Submission No.			047	
Organisation Name or Name of Submitter			Colin Torpay (4 Mary's Abbey, Dublin 7) (Observer form)	
Item No.	Section Ref.	Page No.	Observation Statement	TII Response
Observation on a Strategic Infrastructure Development Application - Railway (Metrolink - Estuary to Charlemont via Dublin Airport) Order [2022]				
1	5. Grounds	3	I would like to make an observation regarding the siting of the St. Stephens Green Station: namely the cut and cover works for the station location, as the project does not seem to have balanced the full range of factors that should have been taken into account. It is troubling that any part of Dublin’s best loved park could ever be considered as suitable for a major cut and cover project for the station while alongside lies an adjacent wide roadway (St. Stephens Green East) with capacity for the station, its entrances and structures, allowing for a successful and complete re-instatement after the works.	<p>TII wish to thank you for your submission, and acknowledge your concerns around the protection of St. Stephen's Green. Appendix A7.3 St. Stephen's Green Report presents the alternative station locations that were considered and assessed

ST. STEPHENS GREEN STATION

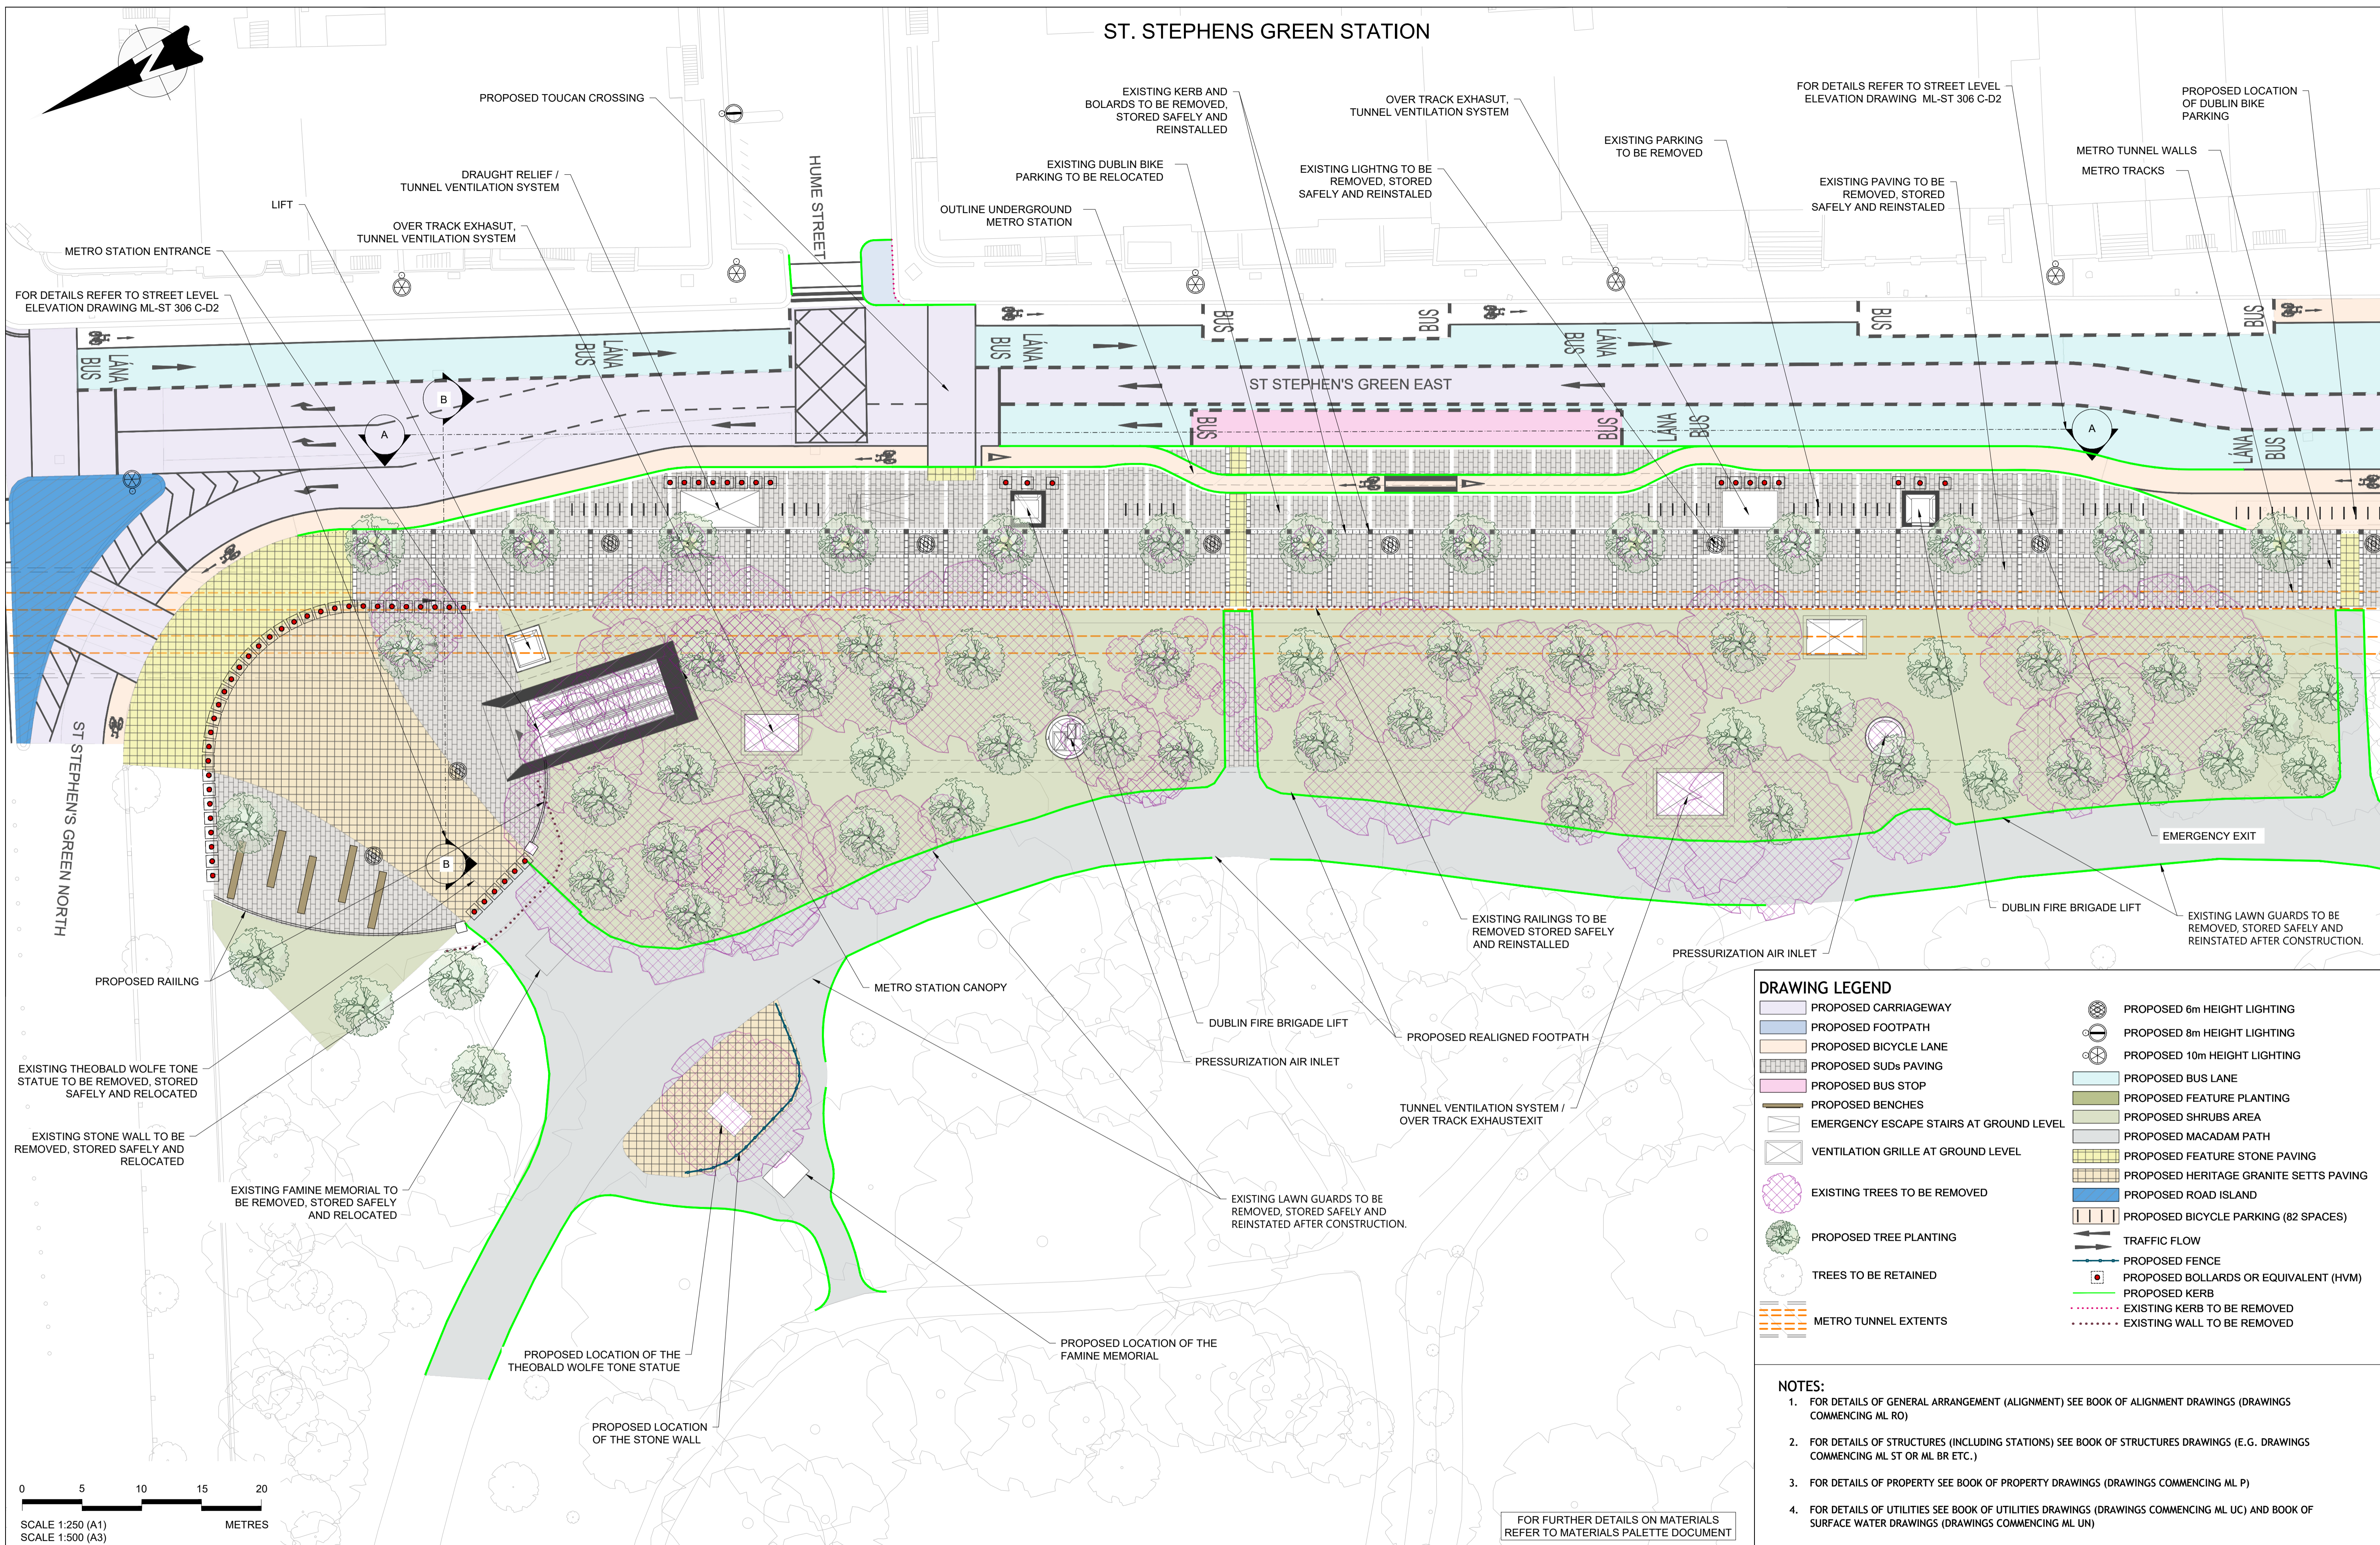
2	5. Grounds	3	While the potential of the proposal is positive in its increased ease of access to St Stephens Green and potential for urban upgrades associated with the works, it throws this opportunity away by not sufficiently acknowledging how outstanding the urban purlieus of this corner of Dublin actually is.	<p>Please refer to response item (1) above in relation to the identification of the preferred station location.</p> <p>TII disagree with the statement regarding sufficient acknowledgement. Chapter 27 (The Landscape) of the EIAR considers the landscape and visual impact of the project and outlines the significance of St Stephen's Green. The proposals for the Project aim to reinstate the existing landscape faithfully as far as is practicable within the constraints which are known to apply. It is feasible to do this, however, as has been set out, it is not feasible to imbue the replacement planting with the level of maturity, the ‘weight’ or the ‘volume’ of the existing tree planting which needs to be removed. This aspect of this approach to restoration of the Park edge will take time. It may be acknowledged that the proposed works can apply a level of mitigation which would go some way to reinstating the disturbed part of ‘the Green’, however, beyond any potential for reinstatement, replacement or restoration, it would be difficult to offset impacts on the maturity and wholeness of this place.</p>

3	5. Grounds	3	It’s an architecturally ingenious park entrance as much as a sculpture, uncluttered and spare, it is a dignified set piece read against the greenery and huge tree canopies behind. That is a successful urban composition. There is really nothing convincing in its proposed re-located position, rendered impotent of function and pushed back out of the way.	<p>With regard to the architectural significance of the entrance, Chapter 25 (Archaeology & Cultural Heritage) of the EIAR identifies that any negative impacts would be offset by an improvement to the current setting and appreciation of the Wolfe Tone monument. The monument would be relocated further into the park, retaining the monument’s historic setting and allowing greater and safer appreciation of the monument as a sculpture, rather than as a barrier. The existing railings and footpath floor finishes will also be preserved. Following mitigation, Chapter 26 (Architectural Heritage) of the EIAR states that “There will be no direct or indirect impacts on architectural heritage during Operational Phase in this section of the study area”.</p> <p>To ensure mitigation is appropriate, the contractor(s) will appoint Consultant Conservation Architects to implement required preservation.</p>

5	5. Grounds	4	These are not insurmountable issues and the protected structure reason highly questionable. It just seems that it is never stated how important St. Stephens Green is, although perhaps this would take up an entire volume and in arguing that a little damage at one side is really nothing. A well-presented section should be provided by the applicant to include the east side from the houses and basements westwards through the park boundary, showing the entire width of the wide road and double pavement outside the park which would really be a telling drawing to combat the main concerns for pushing into the park.	Please refer to response item (4) above in relation to the decision on the location of the St Stephen's Green Station.

Client 	Project METROLINK	Drawing Title METROLINK - PROPOSED SURFACE DRAINAGE SAINT STEPHEN'S GREEN	Drawing Status S0
Consultant JACOBS IDOM	Drawing N° ML1-JAI-URD-ROUT_XX-DR-Y-02093	Plan Drawing N° ML-UN 306 C-D	Sheet 1 of 1
Scales Original Size A1 1:500

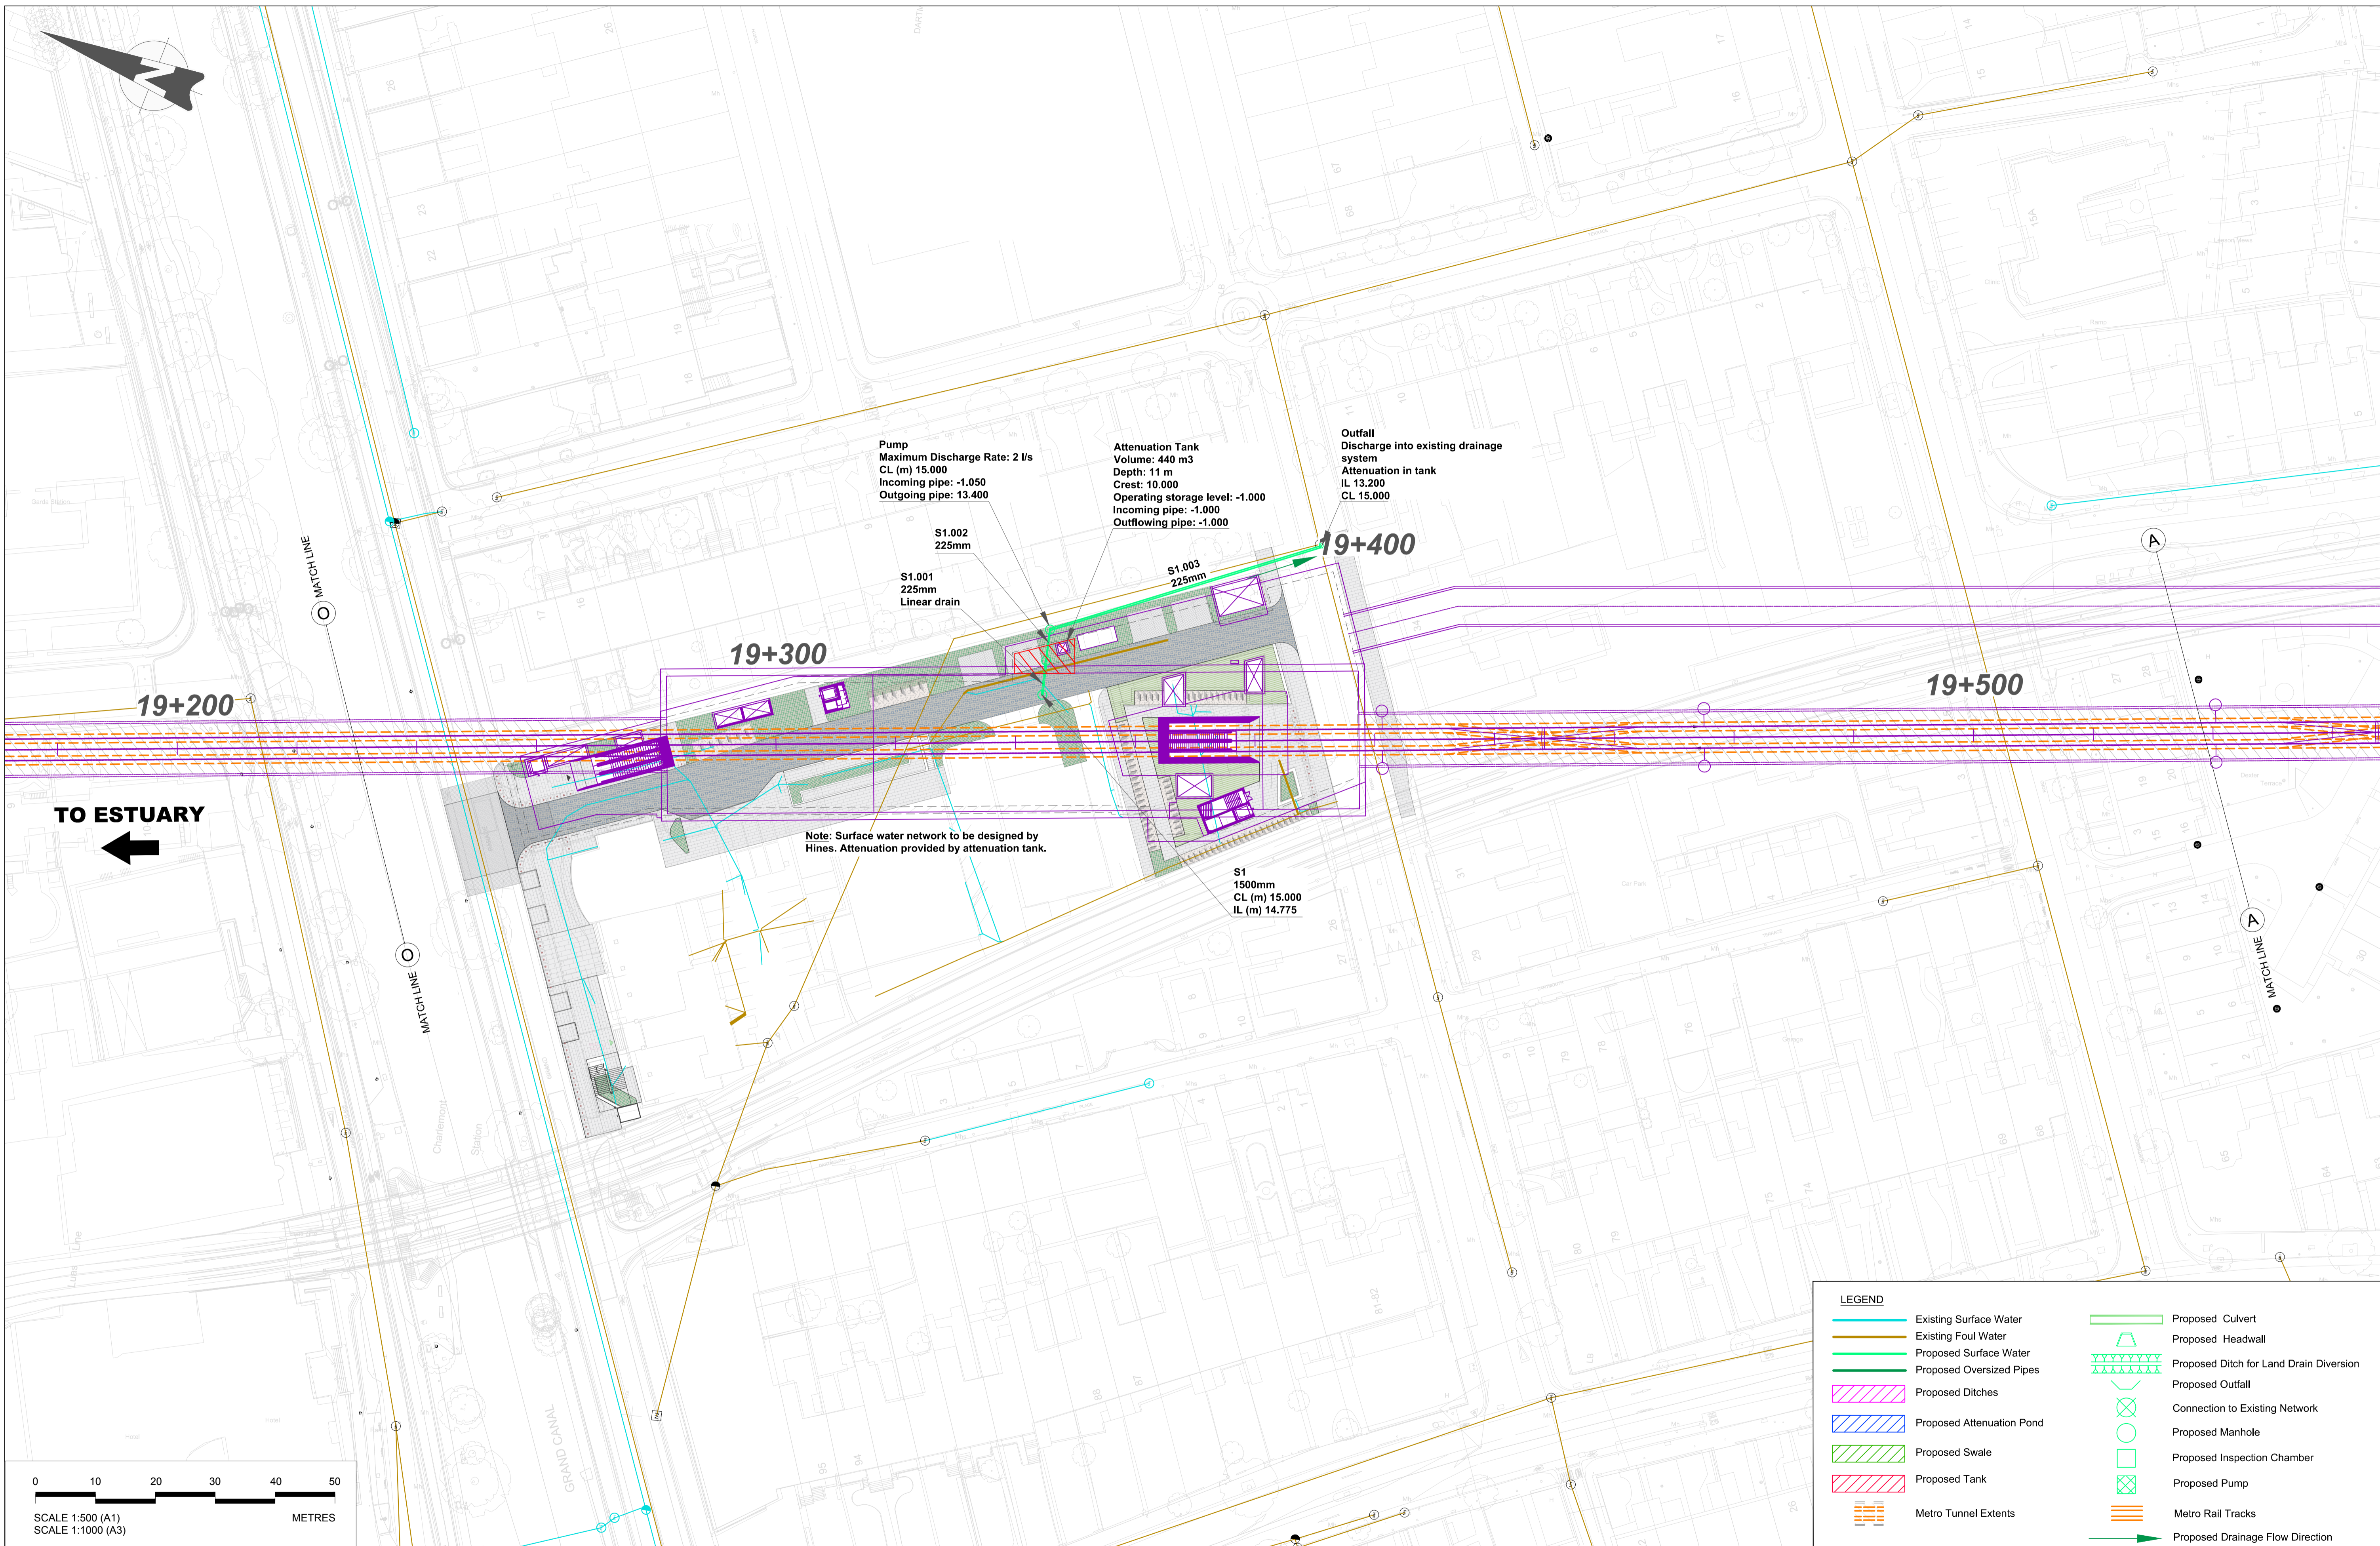
7	5. Grounds	5	Changes to hydrology locally can be detrimental to mature trees.	<p>All stations feature surface drainage systems which are sustainable. Wherever possible surface drainage is conducted to swales/infiltration trenches (as appropriate) which are also integrated into the soft landscape proposals, the impact on mature trees has been considered.</p> <p>Further information in relation to Hydrology and Hydrogeology impacts and assessments is available in Chapter 19 Hydrogeology, specifically section 19.5.3 Construction Phase Impact Assessment and section 19.5.4 Operational Phase Impact Assessment.</p>	
8	5. Grounds	5	The imbalance to the composition of the canopy within the park will be a very damaging outcome, it will be an obvious visual and ecological negative and one that can only recover over generations.	<p>Please refer to response item (6) above in relation to the mitigations proposed for landscape, visual impacts and biodiversity.</p>
